**Consultation Response from Mike Hibbert,
KC Waste Strategy(Refuse & Recycling)**

2023/90076 Units A & B, Leeds Road Retail Park, Leeds Road, Huddersfield, HD1 6PF

Date Responded: 31/01/2023

Responding Ref: WPS 23-01

drawing title
Proposed Site Plan

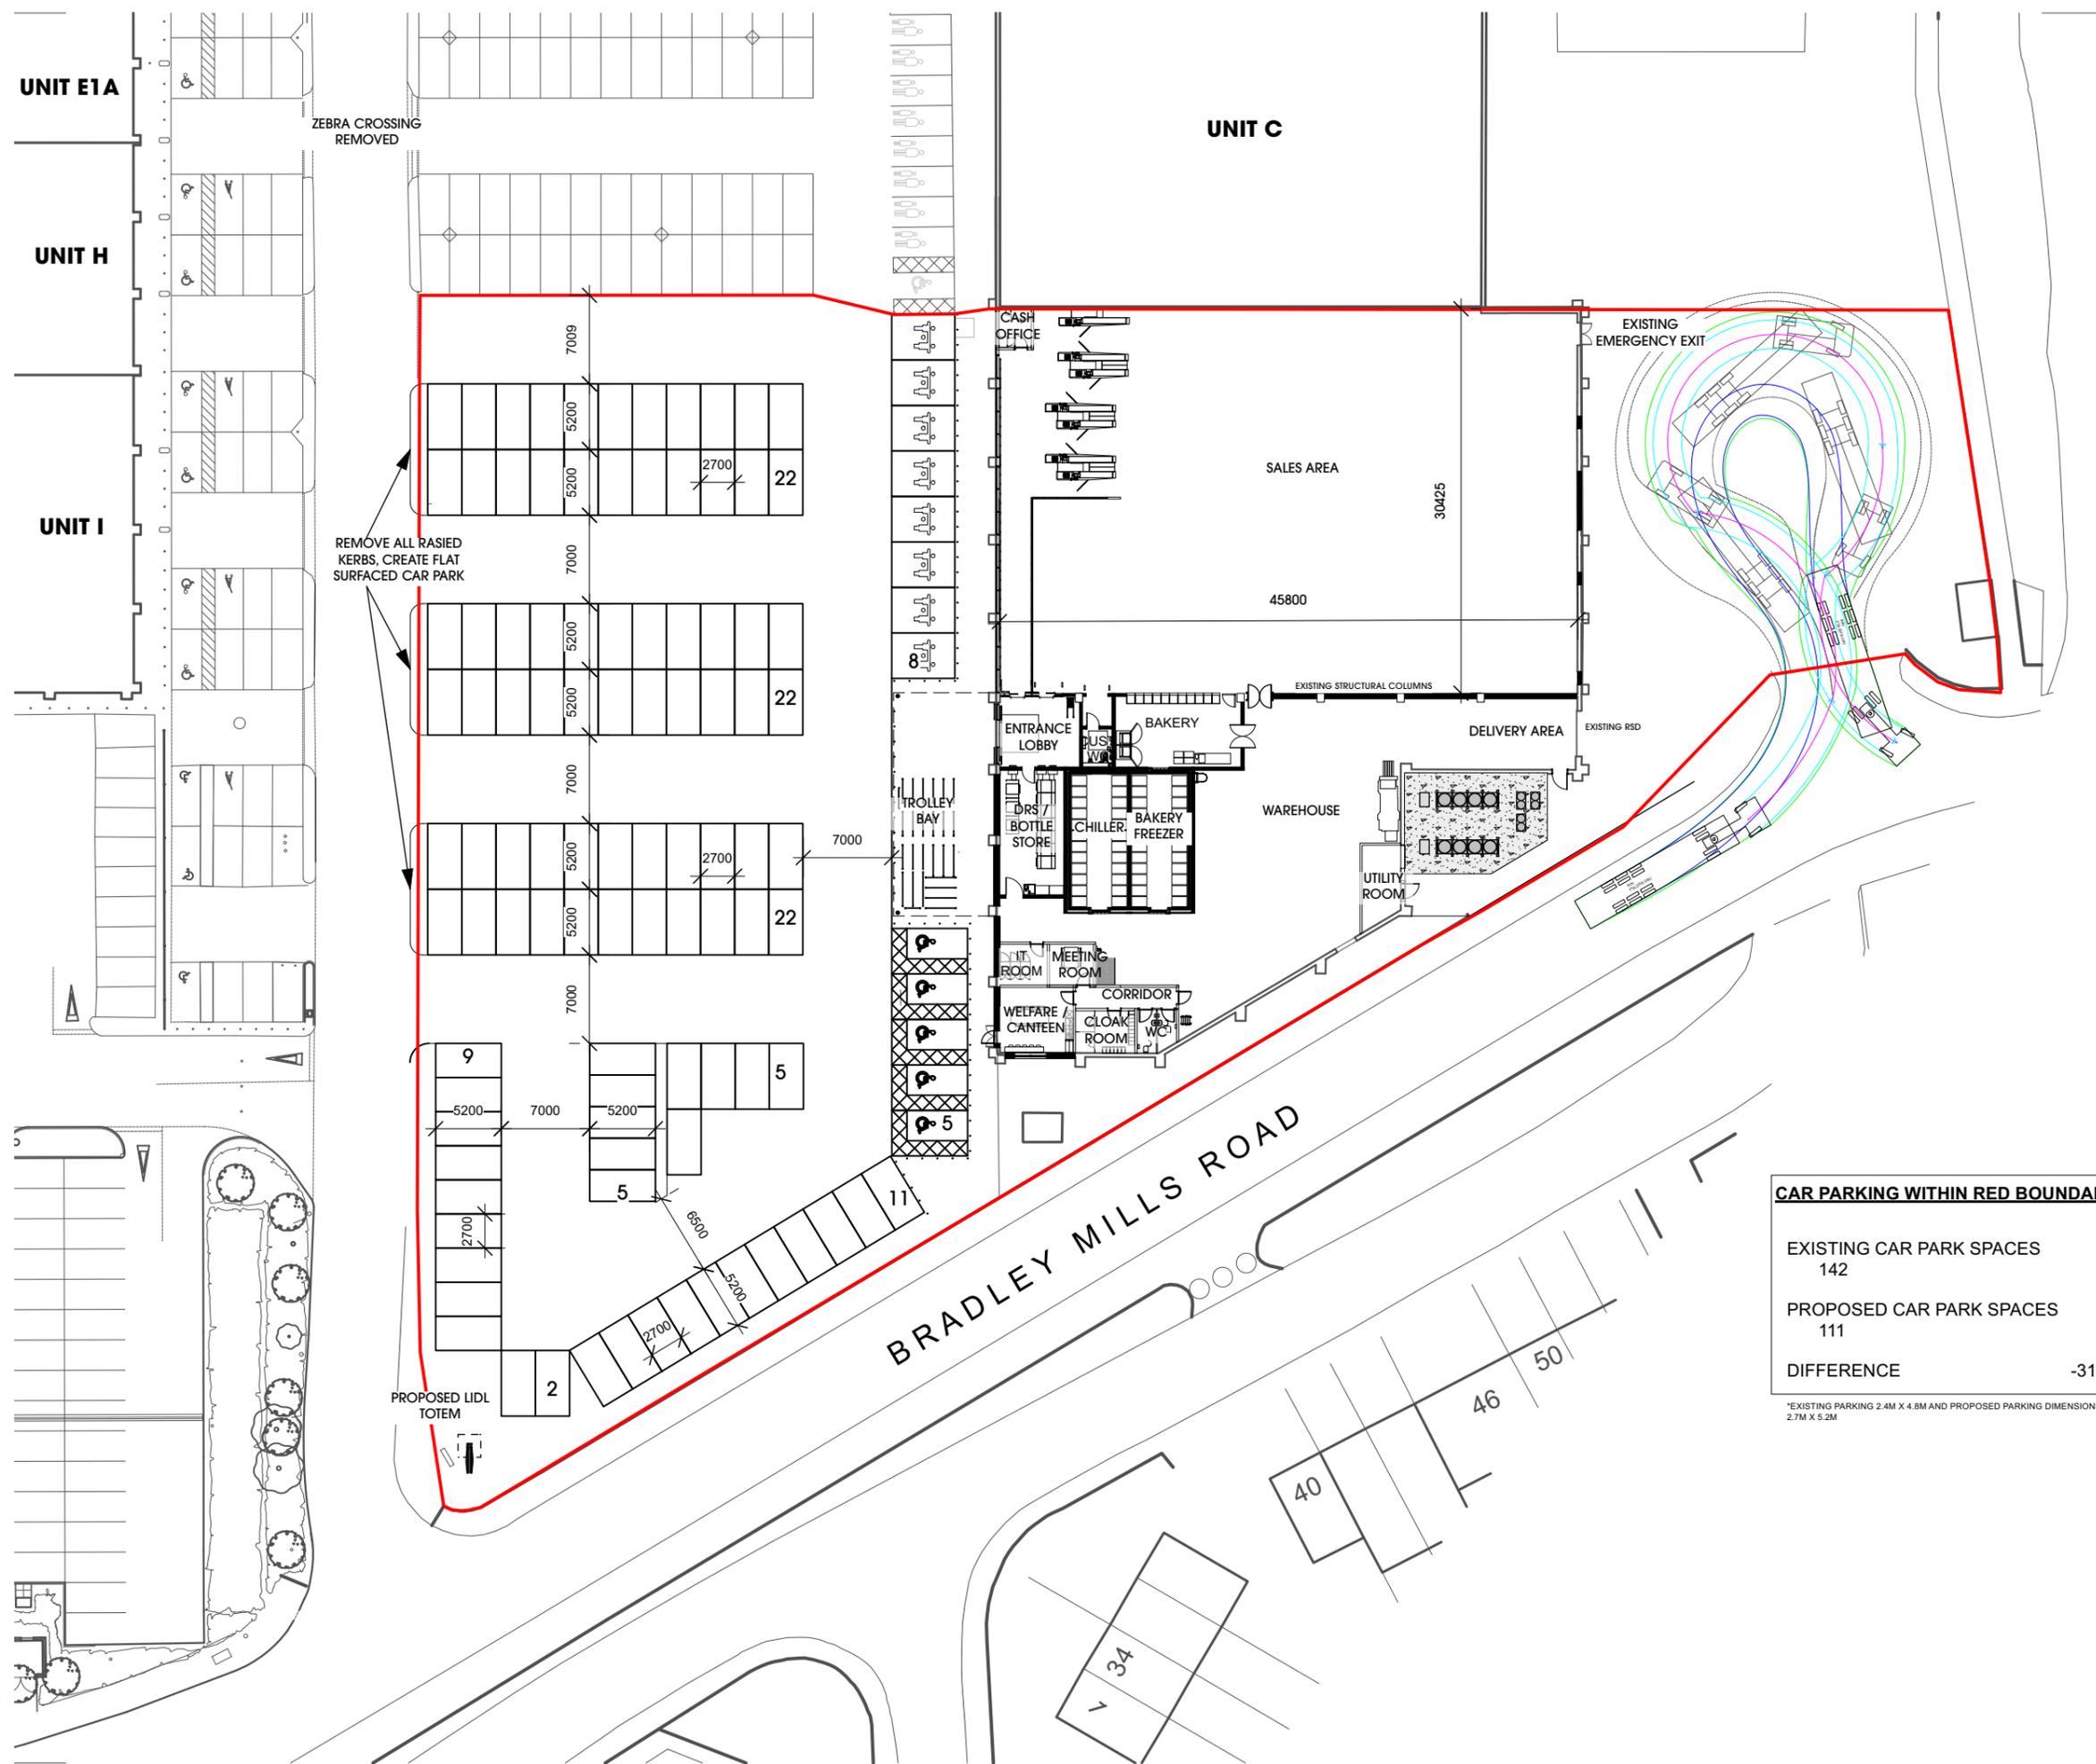
The proposal is for redevelopment of existing retail units for use as a premise operated by Lidl. The application includes a Proposed Site Plan Dwg No P403 Rev F dated 1/11/22

The plan shows a room adjacent to the store entrance annotated as DRS Room. The WCA welcomes that the applicant has made provision of some form of reverse vending equipment to enable collection of polyethylene terephthalate (PET) and High-Density polyethylene (HDPE) plastic bottles, steel /aluminium cans and glass bottles to ensure compliance with proposed Deposit and Return Scheme legislation.

As there are no designated external waste storage locations identified on the plan it is assumed that the operator will be utilising reverse logistics (as is the case at other Lidl stores) with delivery vehicles being used to transport packaging and food wastes to a central collection or distribution depot for onward treatment, recycling or disposal or direct delivery to treatment facilities. On this basis there will not be a requirement for areas on the site for waste skips or wheeliebins and no addition highway access issues for collection vehicles above those regarding delivery of goods to the store.
